KITTITAS COUNTY

MEMORANDUM

TO: All Staff
FROM: Public Works Plan Review Team
DATE: November 21, 2025- Survey Update 12-22-25
SUBJECT: BL-25-00018 Helveston

RECORD OF SURVEY
LOT 1, BLOCK G, SUNLIGHT WATERS II
PART OF THE SOUTHEAST QUARTER OF SECTION 24,
TOWNSHIP 19 NORTH, RANGE 16 EAST, W.M.

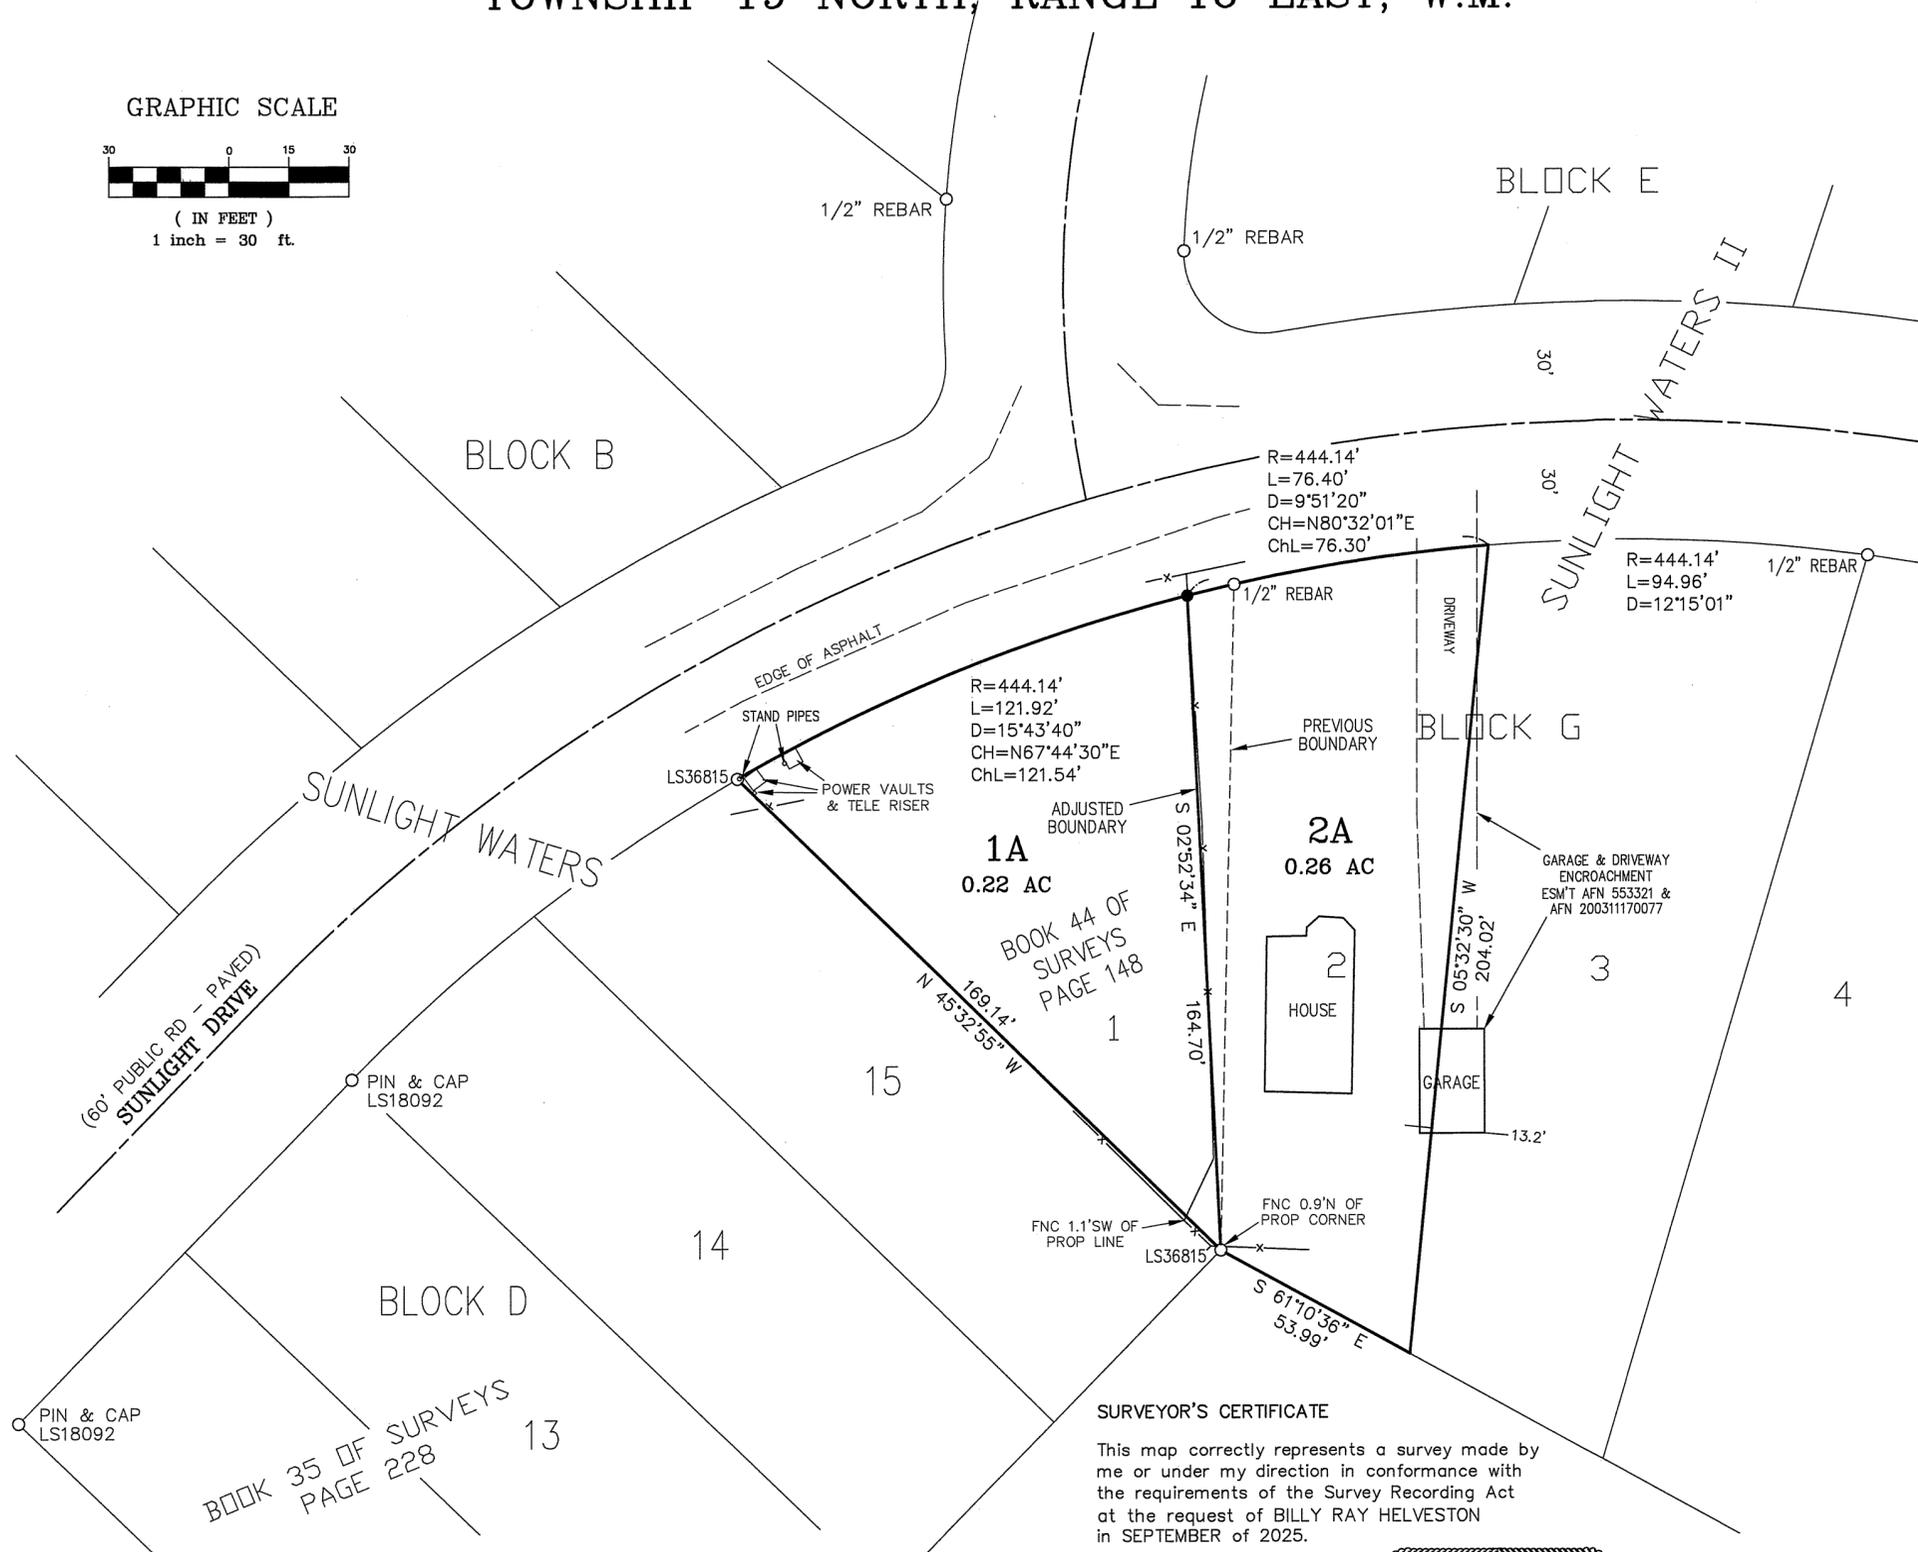
SURVEY	Waiting for final application/Record of Survey before making comments. UPDATE 11/21/2025 1. If any of the found property corners shown were utilized for survey control, bearings and distances to these corners should be shown on the face of the map. 2. Please clarify the diagonal line located near the s'most corner of Lot 1A. OF NOTE Including a label for Ridge Loop Road would be a benefit to the public record. (JT) UPDATE 12/22/2025 The most recent map update has addressed all prior survey comments. (JT)
TRANSPORTATION CONCURRENCY	No Comments.(RC)
